RE: Drainage plan Southerly portion of the Shores development

RE: Morris Manor (formerly called The Shores) and the existing The Shores planned residential development.

RE: Drainage Report for "The Shores" Addition

·Subject: Drainage Report for "The Shores" Subdivision

NOTE: ARROWS INDICATE DIRECTION OF FLOW

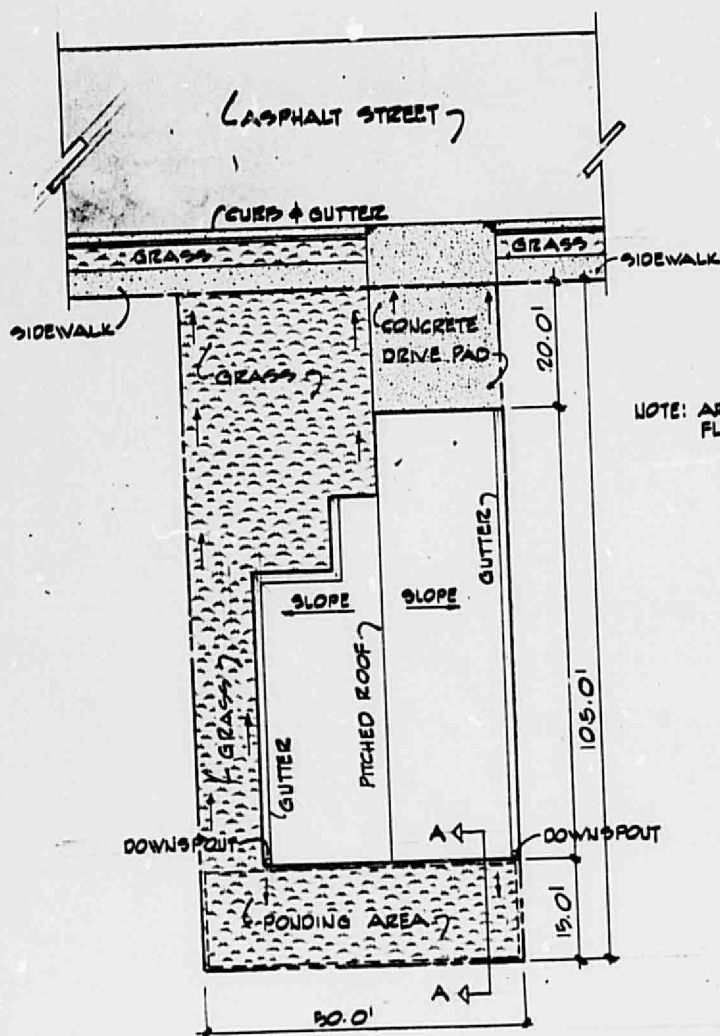
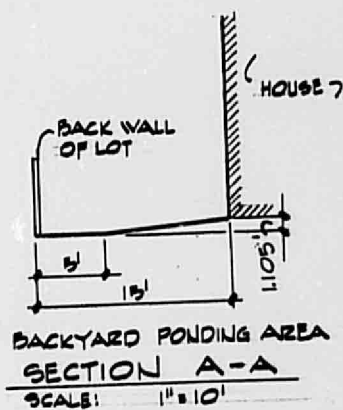
Regarding the question of backyard ponding, an error is noted on page A-3. The surface of the ponding areas is indicated in 72000 sq. ft. while all the previous computations reported a surface area of 32000 sq. ft. Correspondingly, the depth of ponding should be 15.2 in. instead of the indicated 11.0 in.

Since several assumptions are made in the computations, particularly in regard to infiltration rates, it is recommended that the finished floor elevations of the buildings be established a minimum of 6 in. above the level of ponding areas.

Due to a lack of coordination on our part some revisions in our drainage report calculations failed to be included in the final draft of our report. Thus, we are enclosing corrected copies of pages 4, A-2, A-3, and FIGURE 1. We have also incorporated in these revised calculations, the following revised values in order to comply with your recently promulgated STANDARD REQUIREMENTS FOR DRAINAGE PLANS:

As is shown on revised page A-3 and FIGURE 1, the recomputed depth of ponding is 13.26 inches or 1.105 feet.

We accept your recommended note to be also recorded on the plat concerning minimum ponding volume for each lot, etc., except that with the minimum ponding depth recomputed to be 13.26 inches or 1.105 feet, the corresponding minimum ponding volume on each lot should be noted as:

.5 (10' \times 50' \times 1.105') + (5' \times 50' \times 1.105') = 552.5 cubic feet, instead of the 633 cubic feet based on the 15.2 inch minimum depth of ponding that you mentioned in your letter.

GENERAL SITE DATA:
 64 Single Family Dwellings
 11.60 Acres
 9.52 Units/Acre Density
 Present Zoning SU
 Average Lot Size is 55' x 100'

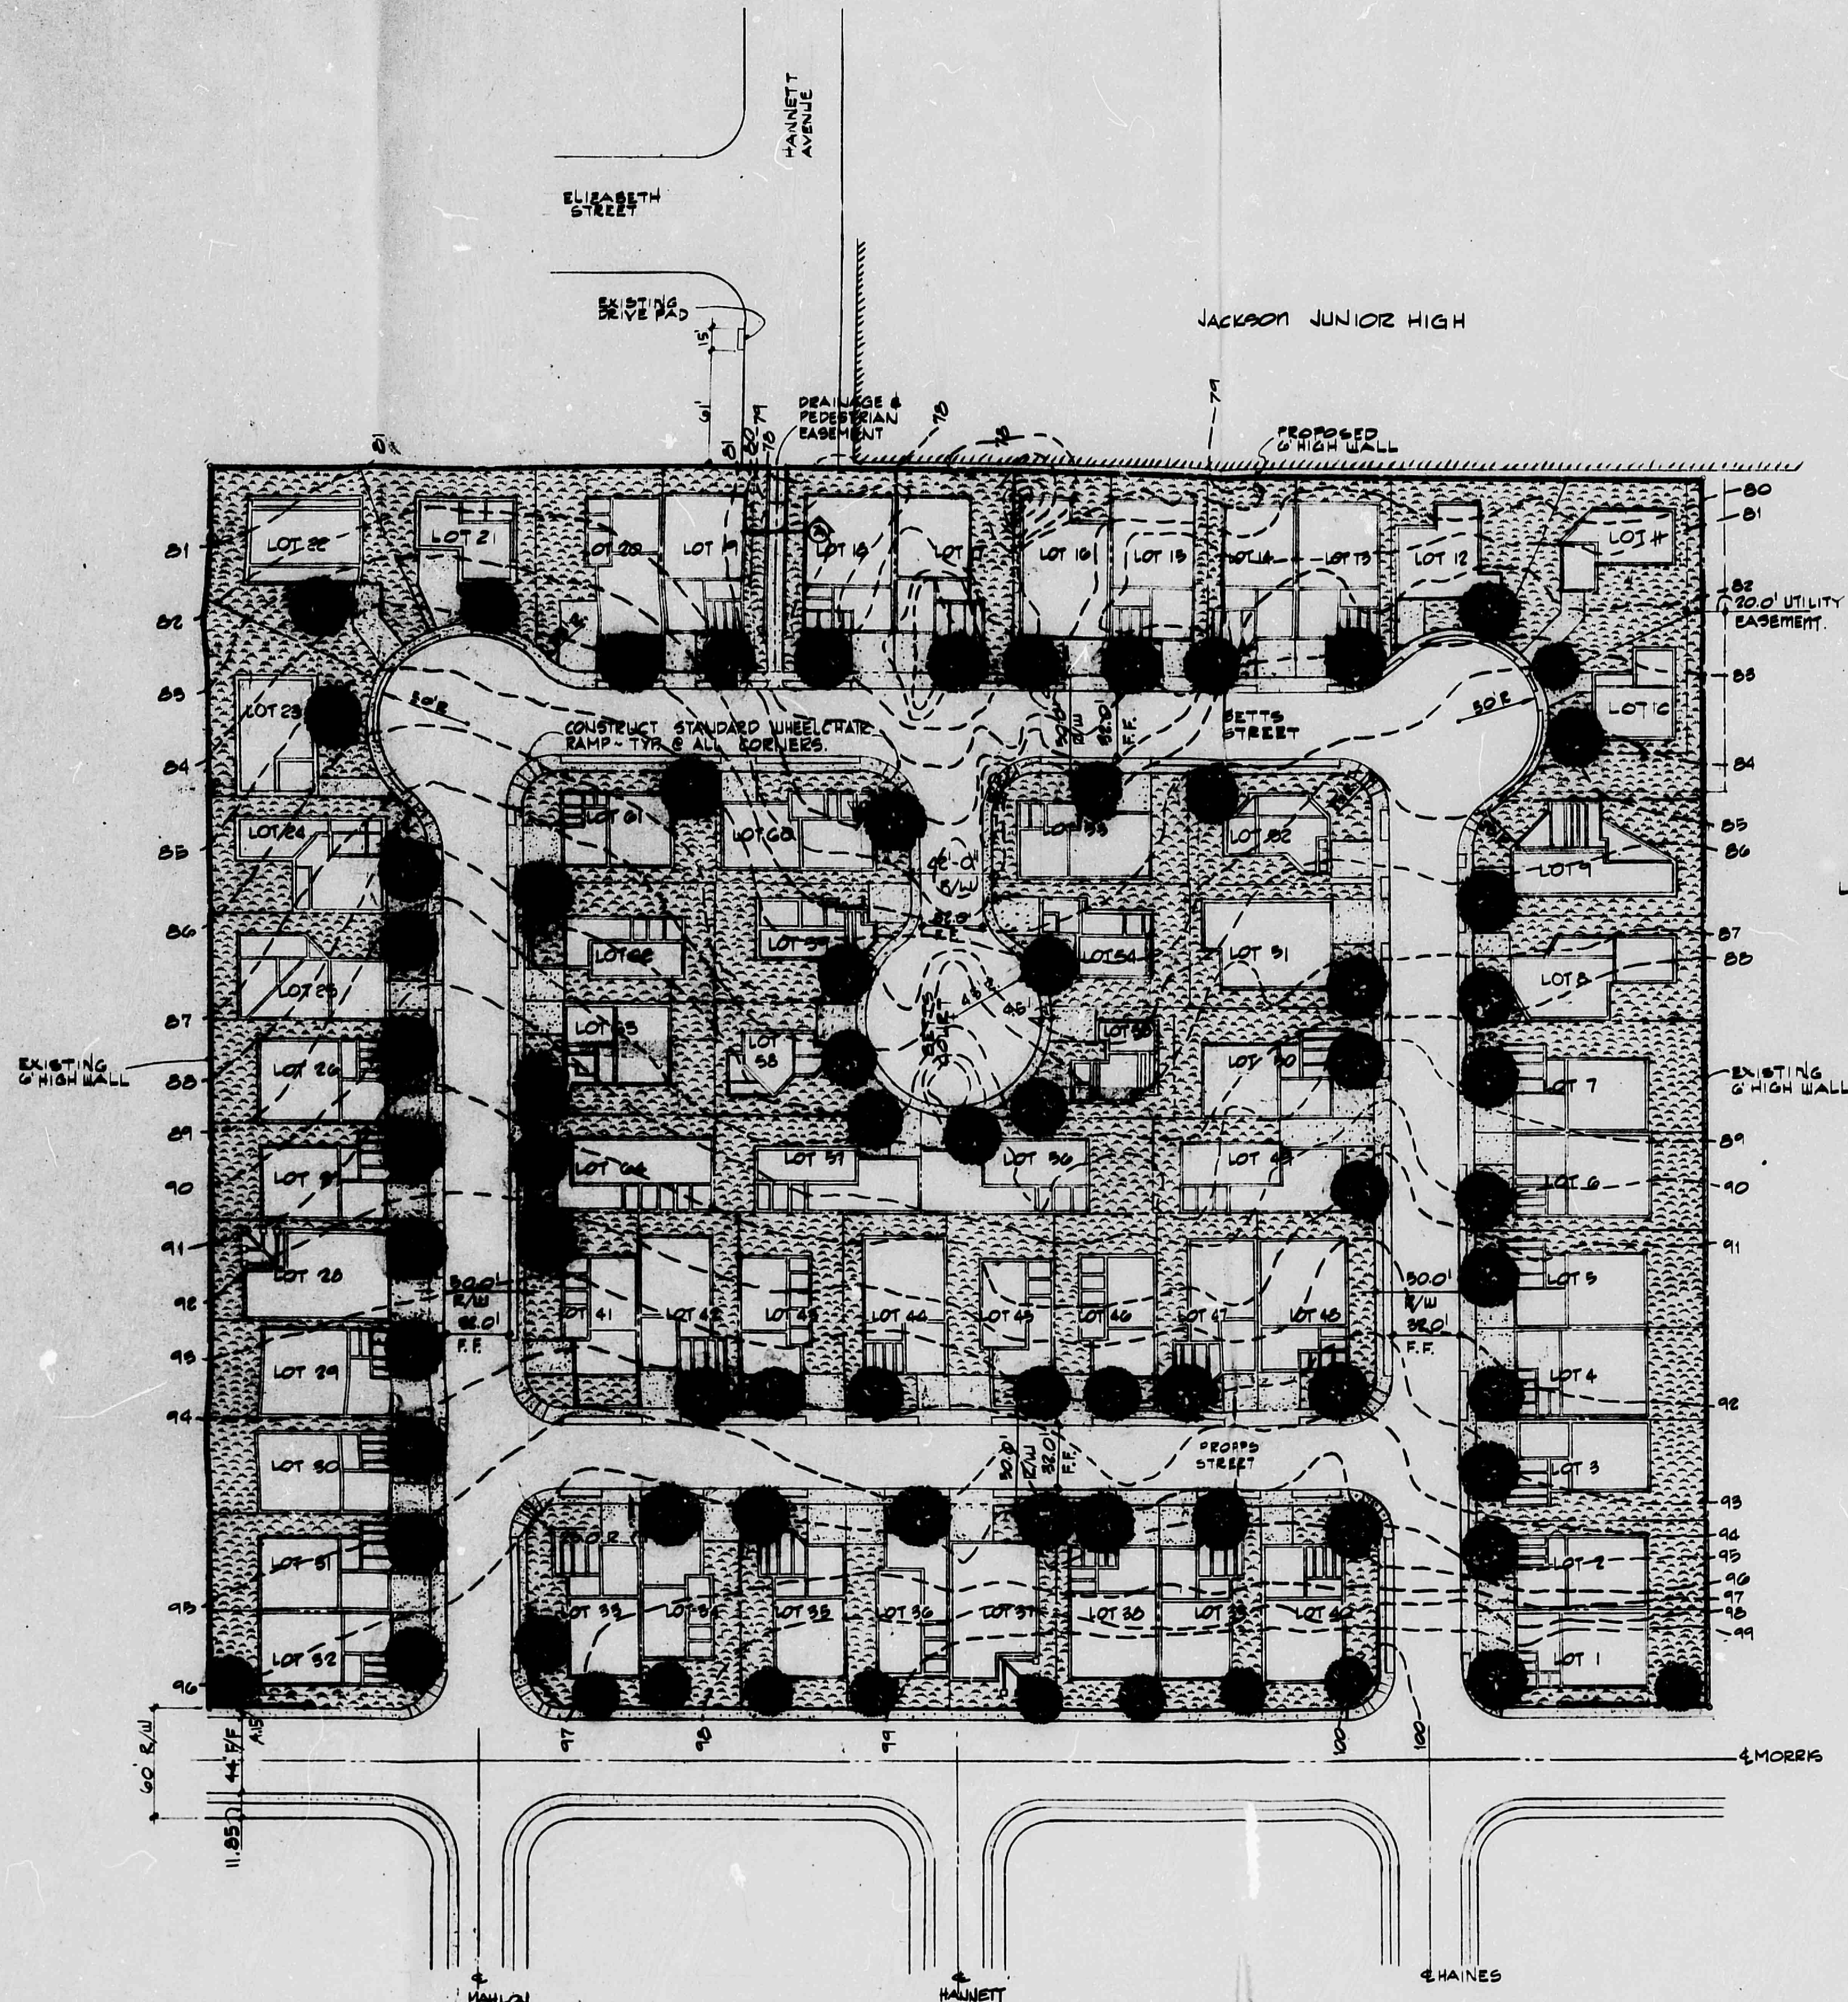
It is further requested that an appropriate <u>drainage easement</u> be dedicated on the plat and that a standard City of Albuquerque rundown be constructed between lots 18 and 19 of this subdivision.

The following note must also be recorded on the plat: "This plat is approved with the condition that each lot be so graded as to provide a minimum ponding volume of 633 cu. ft. on each lot. All the roof runoff must be conveyed to the pond by suitable means. The purchasers of the individual lots will be made aware of the existence of the backyard ponds and of the necessity of preserving and maintaining them. Landscaping with underlying polyethylene film would not be in keeping with the adopted drainage scheme and not acceptable except if compensatory ponding is provided and approved by the City Engineer's Office."

Your recommendation that the finished floor elevations of each building be constructed a minimum of six inches above the top elevation of the back—yard ponding area is accepted and will be so noted on the development plat.

A utility easement will be provided for water, sewer and storm drainage facilities between lots 18 and 19, and will be so indicated on the filed plat. In response to requests by local residents and the Bernalillo County E.P.C. present plans for storm runoff call for the use of a buried conduit in order to limit pedestrian access to the southeast corner of Jackson Junior High School. The final construction plans will show this system and associated grading which will be available for your review.
